RE: SSD-10421-Mod-1 for Weigall Sports Complex

Thank you for notifying Sydney Water of SSD-10421-Mod-1 for Weigall Sports Complex, which proposes design modifications to sports facilities and car park buildings, deletion of the on-site detention system, removal and replacement of trees, construction access and construction hours. Sydney Water has reviewed the application based on the information supplied and provides the following comments to assist in planning the servicing needs of the proposed development.

Sydney Water's Objection

2.14 Easements, Infrastructure & Services

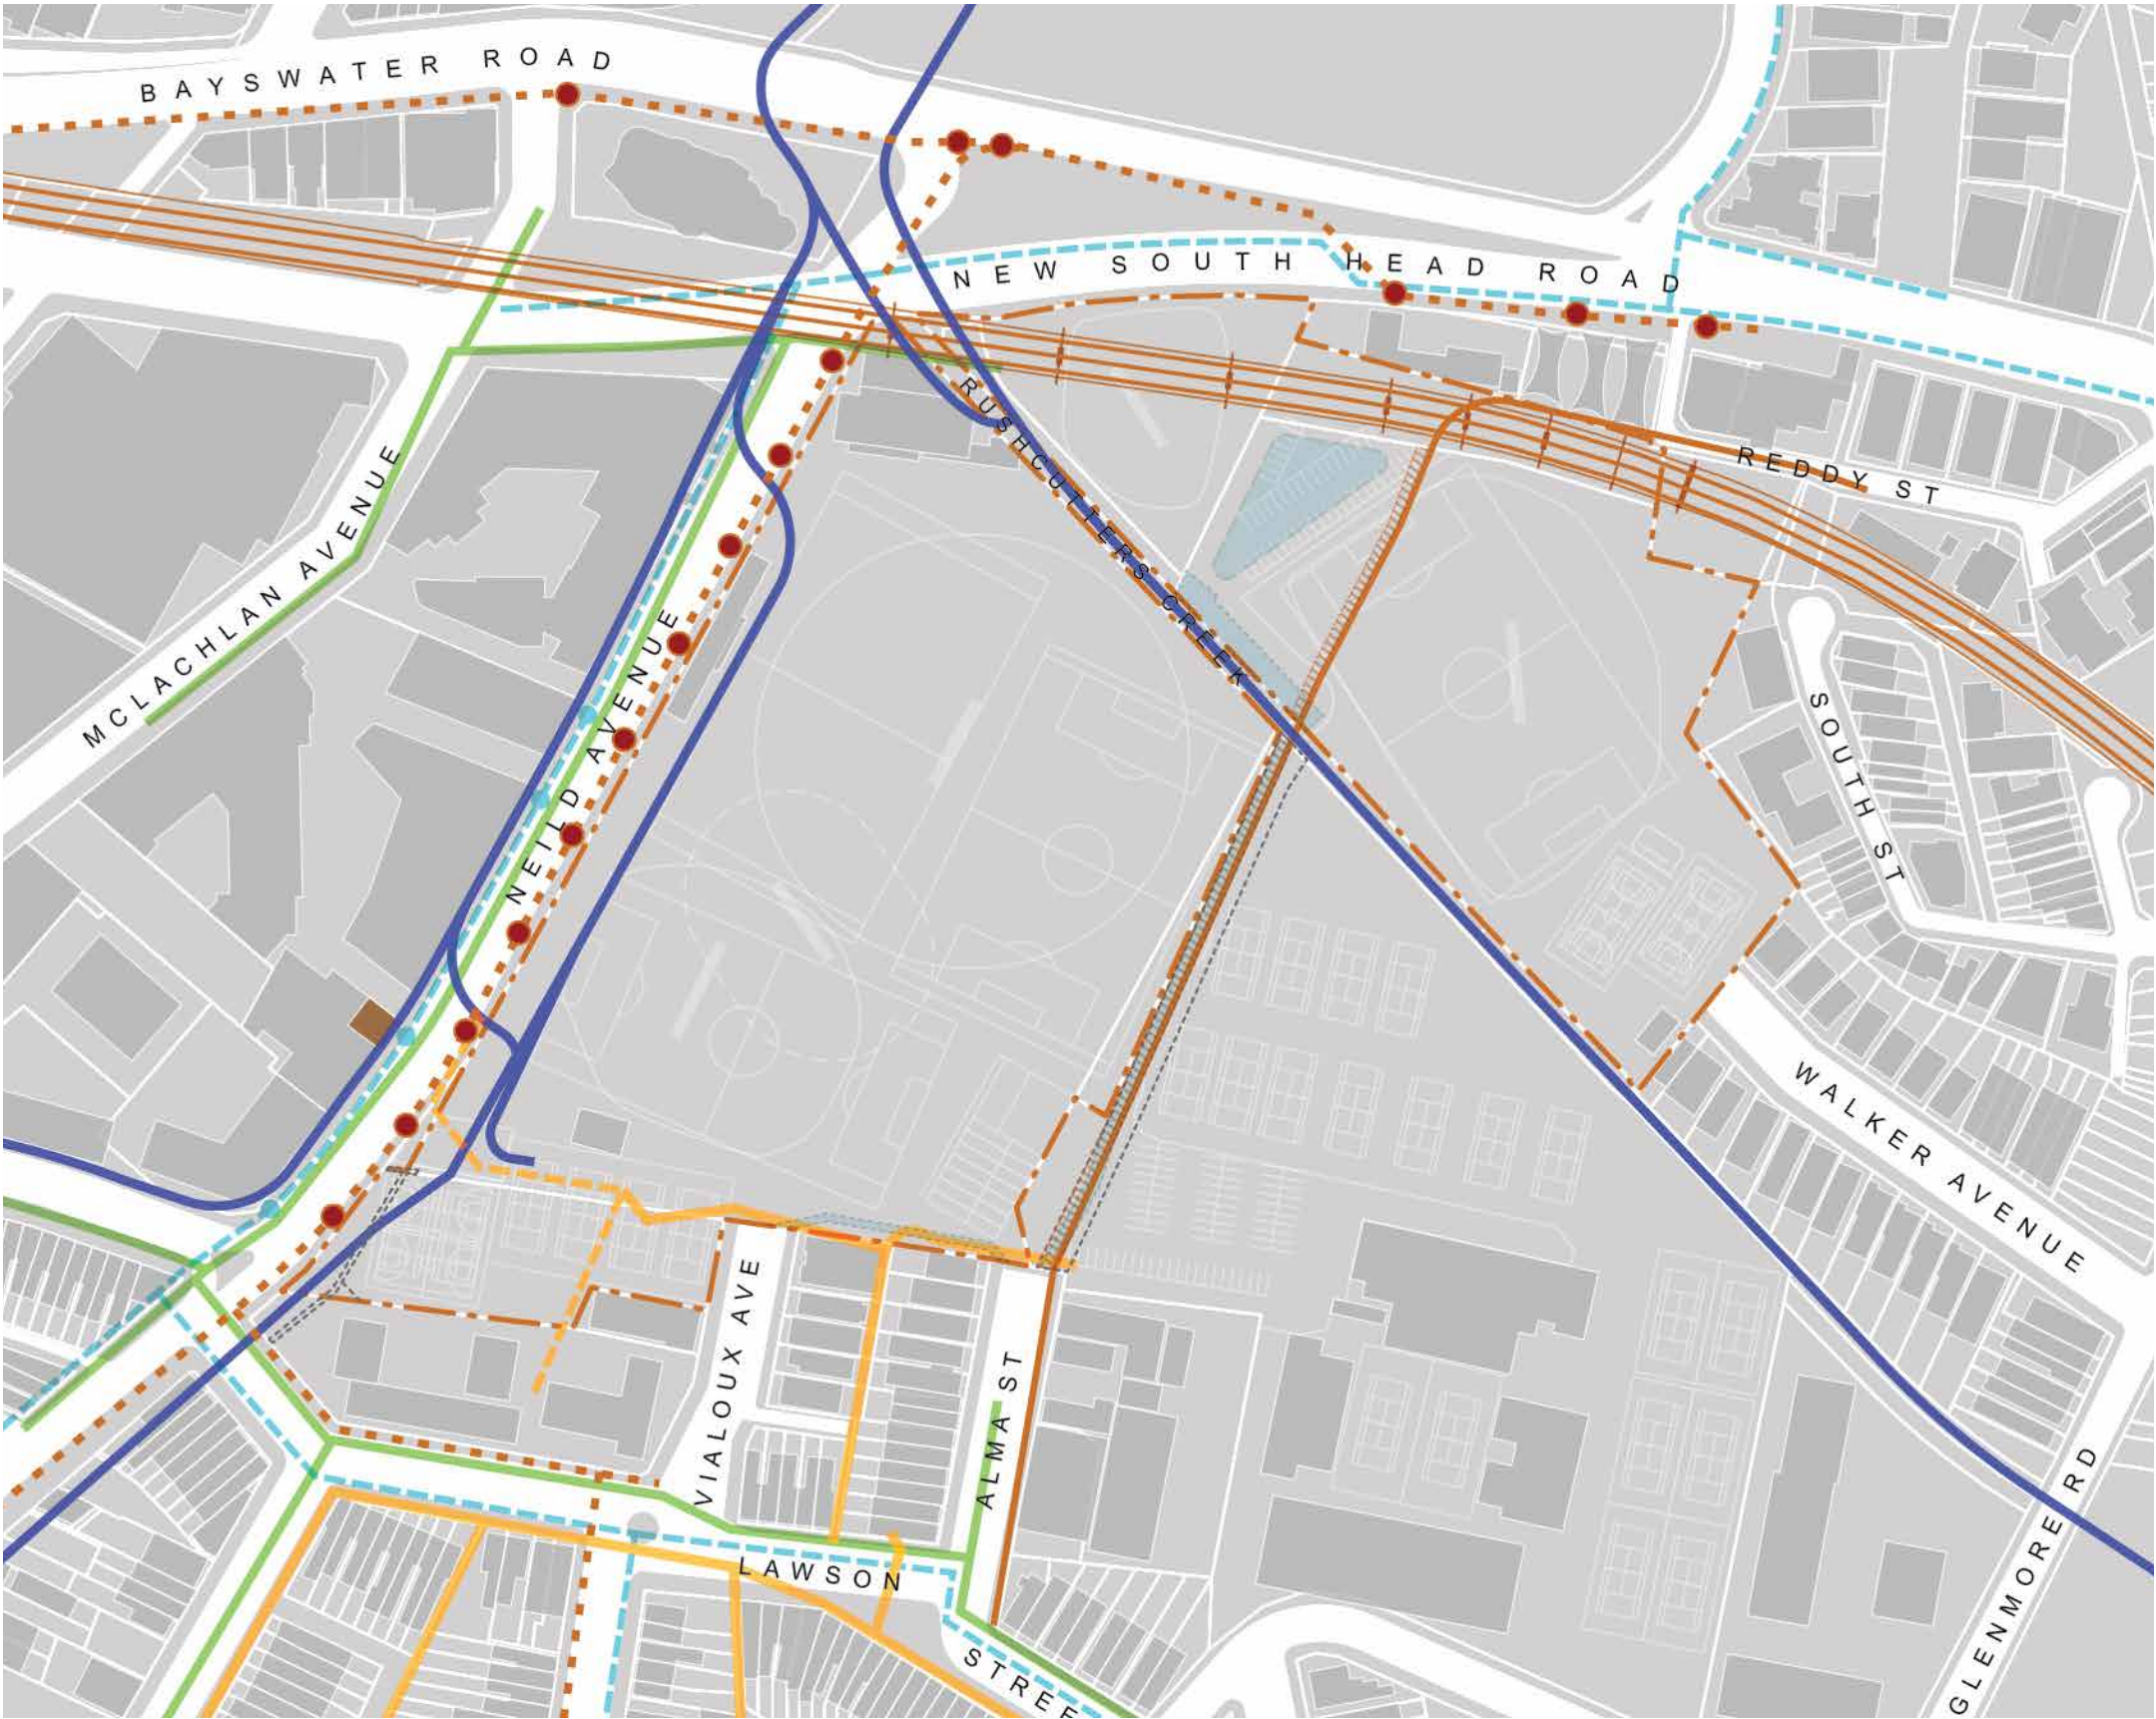
Sydney Water objects to the proposal in its current format as it appears that there are now buildings and permanent structures proposed over its stormwater channel or within 1m from the outside face of the stormwater channel or within the Sydney Water's 10m proposed easement.

Our available records indicate Sydney Water's major 860mm x 990mm stormwater channel and 1,800mm pipe are located within the development site. In addition, there is a 10m wide proposed easement within the development site. Proponent is required to provide evidence that their buildings and permanent structures are 1m away from Sydney Water's stormwater channel and proposed easement or need to revise their proposal to ensure no buildings or permanent structures are proposed over its stormwater channel or within 1m from the outside face of the stormwater channel or within the easement. Permanent structures include (but are not limited to) basement car park, hanging balcony, roof eaves, hanging stairs, stormwater pits, stormwater pipes, elevated driveway, basement access or similar structures. This clearance requirement would apply for unlimited depth and height.

Please also note that any ground level treatment where the quality of the final ground surface is above the quality of standard foot path, such a treatment will not be permitted within the 1m clearance zone of stormwater assets (eg: no tennis court or any artificial turf).

Sydney Water was made aware recently that there is a 10m wide proposed easement within this development site. In the previous submission in 2021 (Attachment 3), we were provided details that the proposed building is away from this proposed easement. However, the current submission appears that there are building and permanent structures within this proposed easement.

The proponent needs to liaise with Sydney Water regarding possible restrictions and requirements in relation to this proposed easement. This may include, that no buildings or permanent structures are allowed within this proposed easement. Firm requirements are not
